One Earth Solar Farm

Written Summary of Applicant's Oral Submissions at the Issue Specific Hearing 2 (ISH2)

Document Reference : EN010159/APP/9.22

September 2025

Appendix D Indicative Open Trench Avoidance Areas

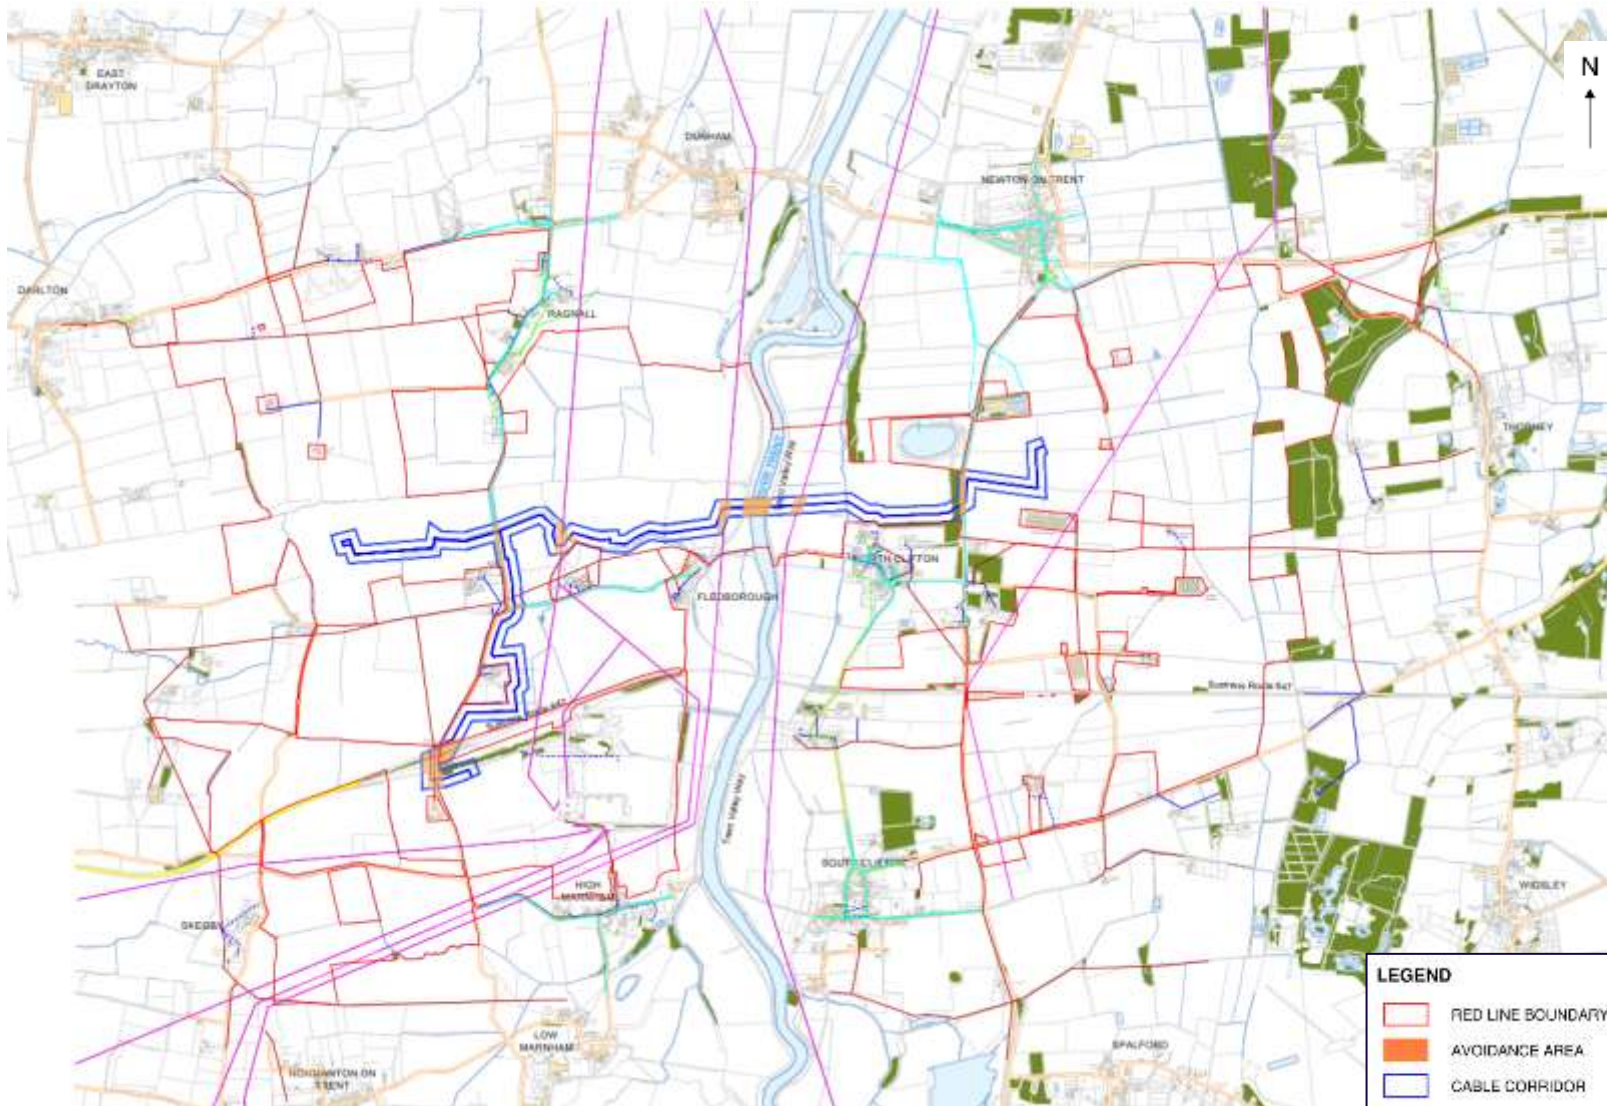
#	Agenda item	Written summary of Applicant's oral submissions
		<p>Mr S Griffiths further noted that, following earlier queries from Mr Walker regarding the accuracy of the photomontages, the Applicant had consulted the team responsible for their preparation and the Applicant is satisfied that these are accurate and reliable.</p> <p>In response to a question from Mr White regarding whether fencing is proposed in at Trent Lane, Mr R Griffiths, on behalf of the Applicant, confirmed that there are no plans to install fencing in that area.</p> <p>Addressing broader concerns raised by Mr White and Mr Walker about the methodology used to generate the 3D images, Mr S Griffiths clarified that the Applicant had not relied on generic tools such as Google Earth. Instead, the visualisations were produced using site-specific LiDAR scans, which underpin the accuracy of the photomontages.</p> <p>Post hearing note: The Applicant has provided supplementary information to explain the process undertaken to prepare the photomontages. This information is provided in Appendix A and comprises: LiDAR scans for two viewpoints, a summary of the methodology utilised in the preparation of the images, and the addition of a person (measuring 1.5m) and measure stick in one photomontage. This information has been prepared to provide greater transparency and confidence in the reliability of the imagery presented. (ExA Action 4)</p> <p>The ExA sought clarification from the Applicant regarding the adequacy of proposed mitigation measures for tree and hedgerow protection, particularly in relation to cable routing, access track siting, and visibility splays. The ExA referenced previous submissions at Deadline 2 and requested further assurance that the detailed design would avoid adverse impacts on root systems and vegetation, and that visual impacts from new access points would be appropriately managed.</p> <p>Mr S Griffiths, on behalf of the Applicant, confirmed that a detailed arboricultural impact assessment will be undertaken at the detailed design stage. To date, assessments have been based on high-level information, but further refinement will follow once the final alignment is known.</p> <p>Mr. S Griffiths noted the mitigation of potential adverse impacts associated with proposed vehicular access points, the access locations have been located to utilise existing access points where possible. Where this has not been achievable, locations with little vegetation have been preferred. Wider vegetation within the visibility splay is proposed to be maintained at a height of 0.9m, rather than removed, during construction. This is secured through the Vegetation Removal Plan which is Appendix C of the Outline Landscape and Ecological Management Plan [REP2-056].</p> <p>Regarding tree and hedgerow protection, Mr S. Griffiths referred to these being secured within the Outline Design Parameters [REP2-022] as follows:</p> <ul style="list-style-type: none"> Hedgerows: 5m – measured from the centreline, as defined by the topographic survey commissioned by the Applicant.

#	Agenda item	Written summary of Applicant's oral submissions
		<ul style="list-style-type: none"> Watercourses, drainage ditches, and waterbodies: 10m – measured from the water's edge, as defined by the topographic survey commissioned by the Applicant. Trees: 15m – measured from the edge of canopy, as defined by the topographic survey commissioned by the Applicant. Woodland: 25m – measured from the edge of canopy, as defined by the topographic survey commissioned by the Applicant. Veteran trees: no works within Root Protection Area (RPA). <p>These Outline Design Parameters are commitments that will inform the detailed design which will be submitted for approval by the local planning authorities under Requirement 5. The OLEMP [REP1-053] which states at para. 5.3.6 that RPAs for individual trees (including identified veteran trees) will be accounted for during construction and habitat creation to ensure tree retention and to avoid damage, in accordance with British Standard 5837:2021 'Trees in relation to design, demolition and construction'.</p> <p>Mr S. Griffiths identified the Outline Construction Environmental Management Plan (OCEMP) [REP2-049] as the key securing mechanism for embedded landscape mitigation associated with cable routing. It also sets out that the micro-siting of infrastructure to protect RPAs will be undertaken at detailed design (Table 3.14) and commits to <i>"the cable route will be positioned as far from the stem of retained trees as possible and all trenching will be outside of the RPA of retained trees"</i>. It goes on to state that <i>"Trenchless crossings such as horizontal directional drilling will be utilised as required to mitigate impact on tree belts or hedgerows."</i> A Construction Environmental Management Plan will be submitted for approval under Requirement 13.</p> <p>Installation of the Export Cable Route will be accompanied by the reinstatement of the working width which will include the re-planting of areas where they were previously vegetated. This also includes the backfilling of trenches with topsoil and seeding to restore land to its original condition. This is mentioned in the Outline Export Cable Route Construction Method Statement [APP-185].</p> <p>On the matter of Trent Lane, Mr R Griffiths confirmed that:</p> <ul style="list-style-type: none"> Trent Lane is identified on the Streets, Rights of Way and Access Plans, with the public right of way marked between PROW12/03 and PROW12/10. Powers sought under Schedule 6, Part 4 of the draft DCO [REP2-009] relate only to temporary management during construction for safety purposes. No powers are sought for closure or management during the operational phase. The only permanent infrastructure will be a below-ground jointing bay, covered by a manhole cover, with no above-ground structures.
